Immingham Green Energy Terminal

9.3 Applicant's Responses to the Examining Authority's First
Written Questions

(Responses to "Q1.1. General and Cross-cutting")

Document Reference: TR030008/EXAM/9.3

FIGURE TITLE
Site and Surrounding Environment
Key Plan

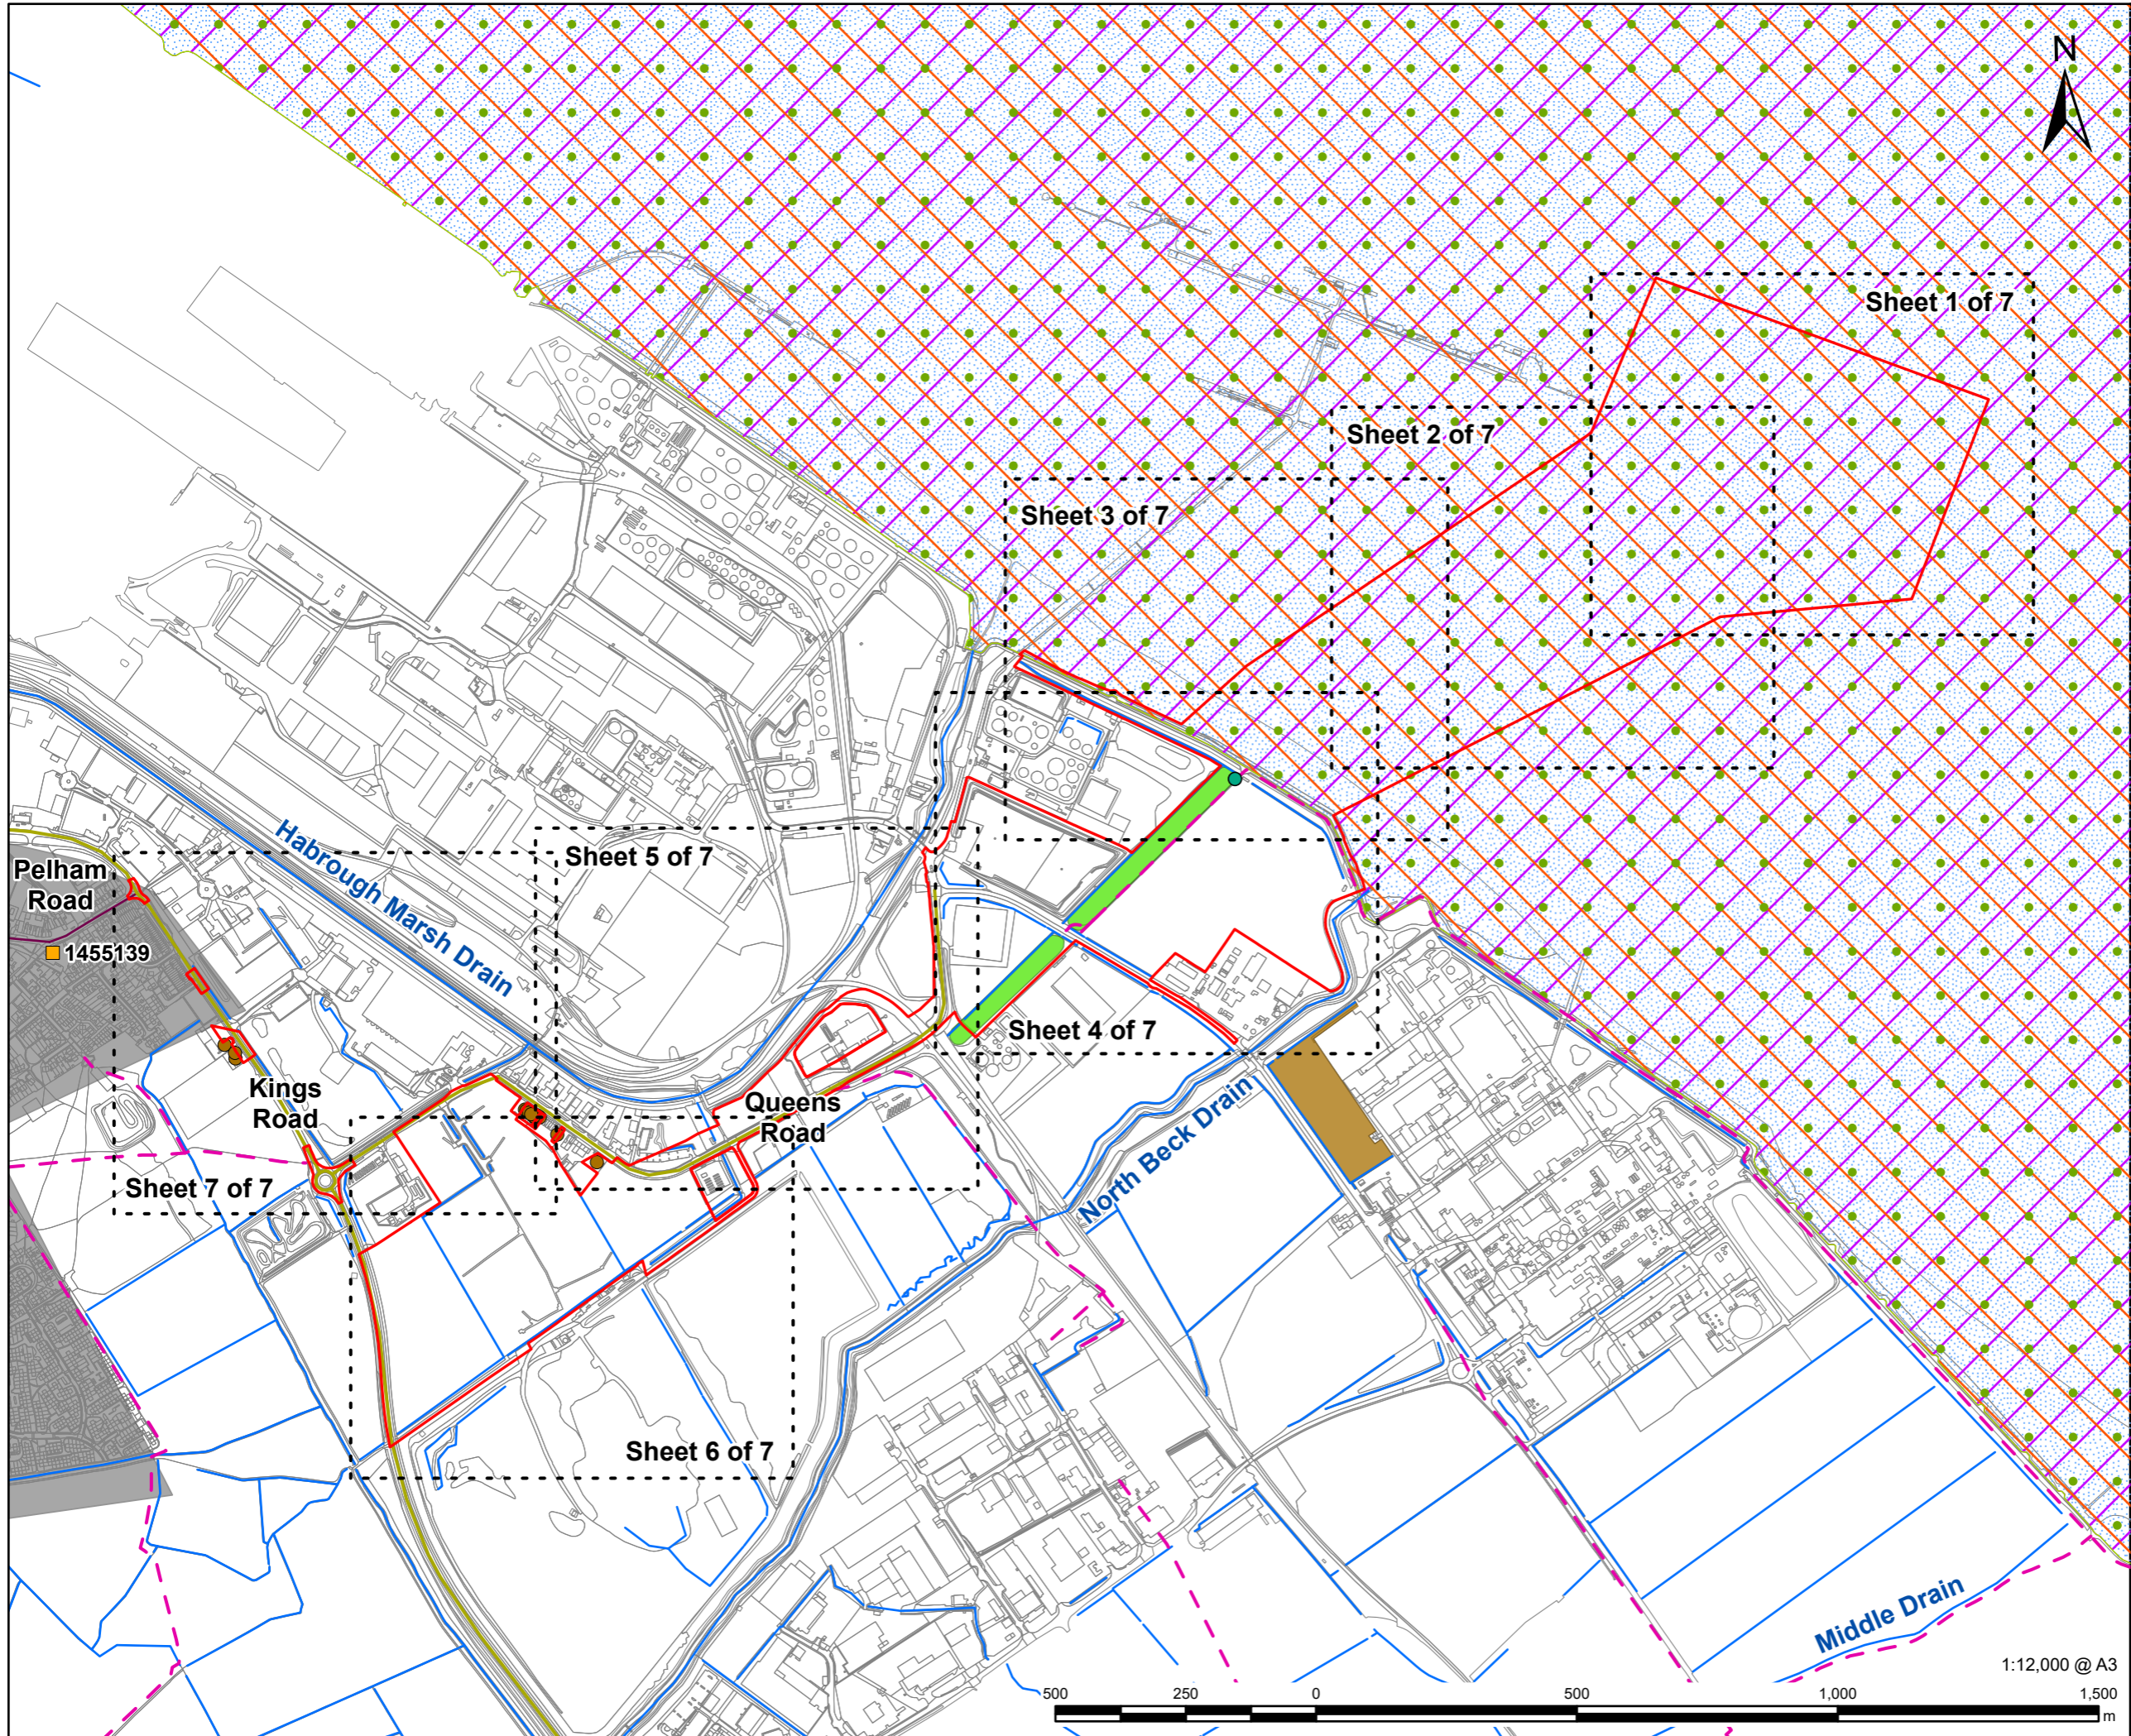
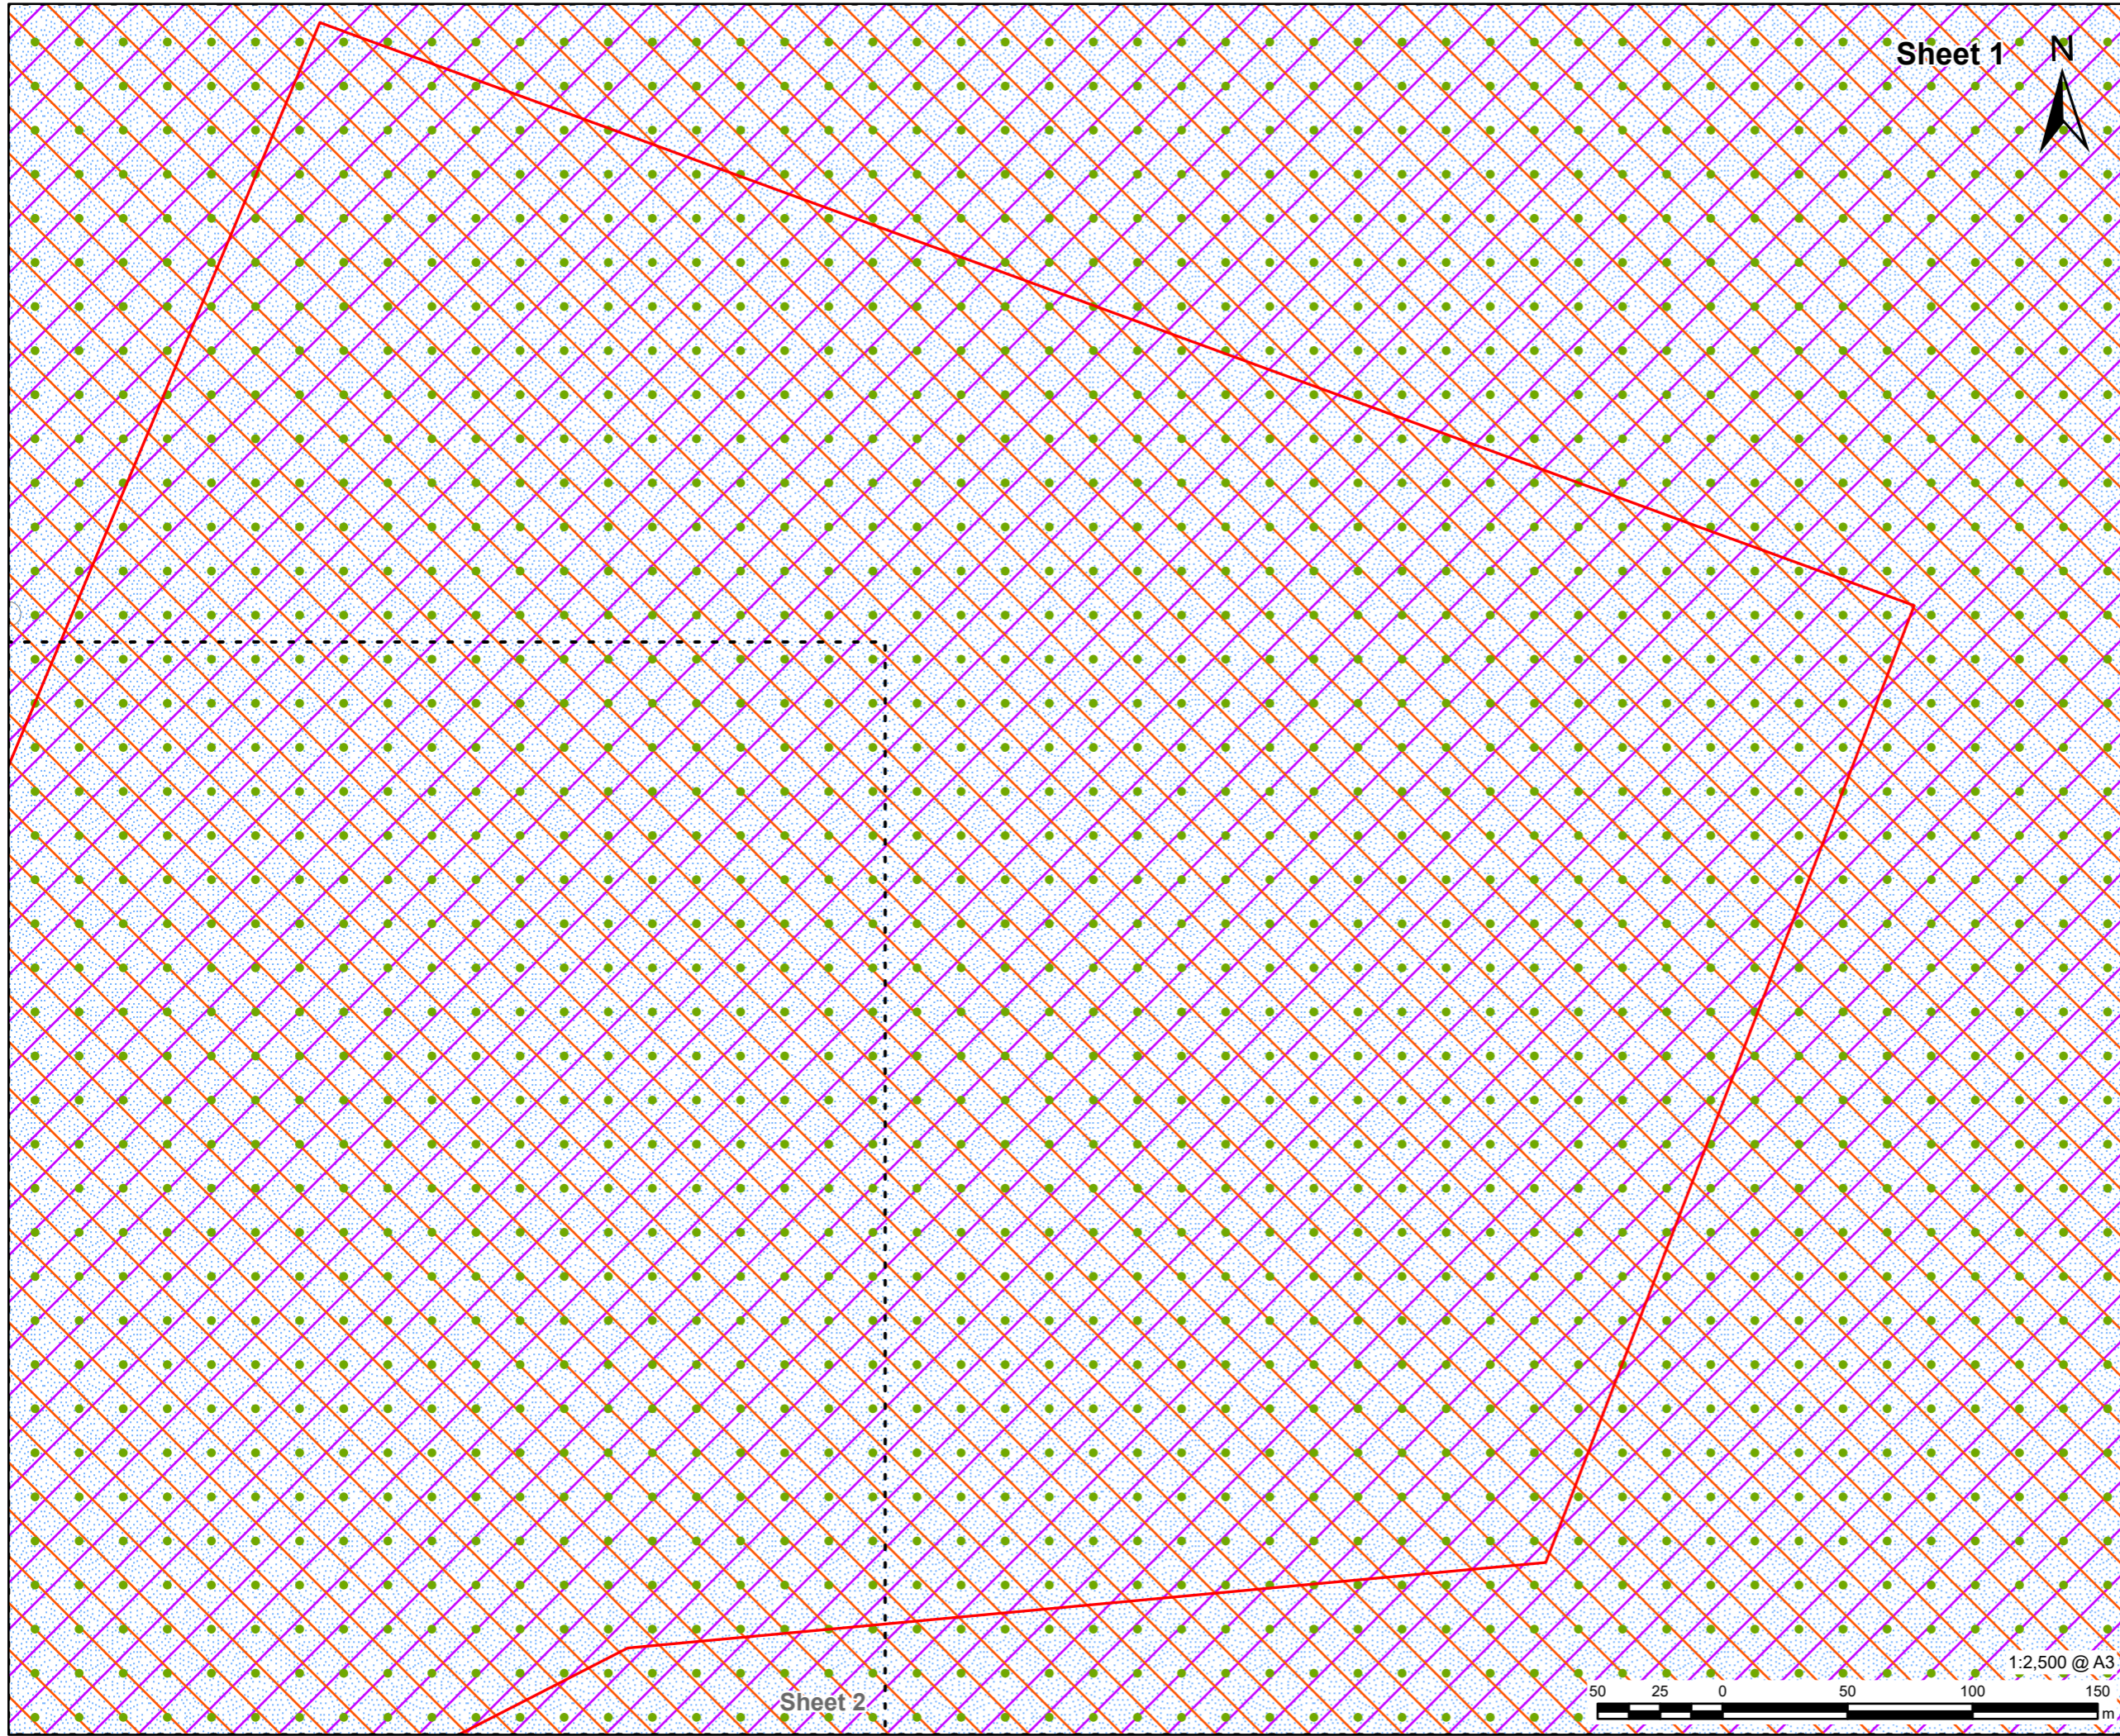
<p>Document Correction</p> <p>ES [APP-181, Appendix 8.B, Paragraph 2.3.14] states that the Long Strip south of Laporte Road is not included in the site boundary. However, it is included on all the site maps. Explain or clarify or correct this document.</p>	<p>The Long Strip south of Laporte Road is included in the Site Boundary. Paragraph 2.3.14 within ES Appendix 8.B: Preliminary Ecological Appraisal Report [APP-181] should state:</p> <p><i>“A narrow band of woodland approximately 40m in width located on the north side of Laporte Road; the same woodland band also continues south from Laporte Road and is essentially split into two halves by the road. Both sections of woodland are within the Site Boundary.”</i></p> <p>The Table of Errata [PDA-010] submitted at Procedural Deadline A also provides the corrected text.</p>
<p>Q1.1.1.4</p>	
<p>Question</p>	<p>Response</p>
<p>Transboundary</p> <p>Considering all aspects of the Proposed Development, would there be any issue which may affect transboundary matters or foreign countries? If so, what would be the magnitude of these impacts, and would these be adverse in nature?</p>	<p>The Planning Inspectorate undertook a transboundary screening for the purposes of Regulation 32 of the Infrastructure Planning (Environmental Impact Assessment) Regulations 2017 on 2 March 2023 following the Applicant's request for a Scoping Opinion.</p> <p>The Planning Inspectorate concluded that the Project is likely to have a significant effect on the environment in a European Economic Area (“EEA”) state, and subsequently Denmark and Iceland were notified of the Project. The reason for notification related to the potential impacts on bird populations of conservation importance.</p> <p>The Planning Inspectorate published a second Transboundary Screening on 1 February 2024, concluding that no new EEA states had been identified as being likely to have significant effects on their environment. On a precautionary basis, Iceland would be notified of the Project and Denmark would be consulted as they had requested to be involved in the transboundary consultation.</p>
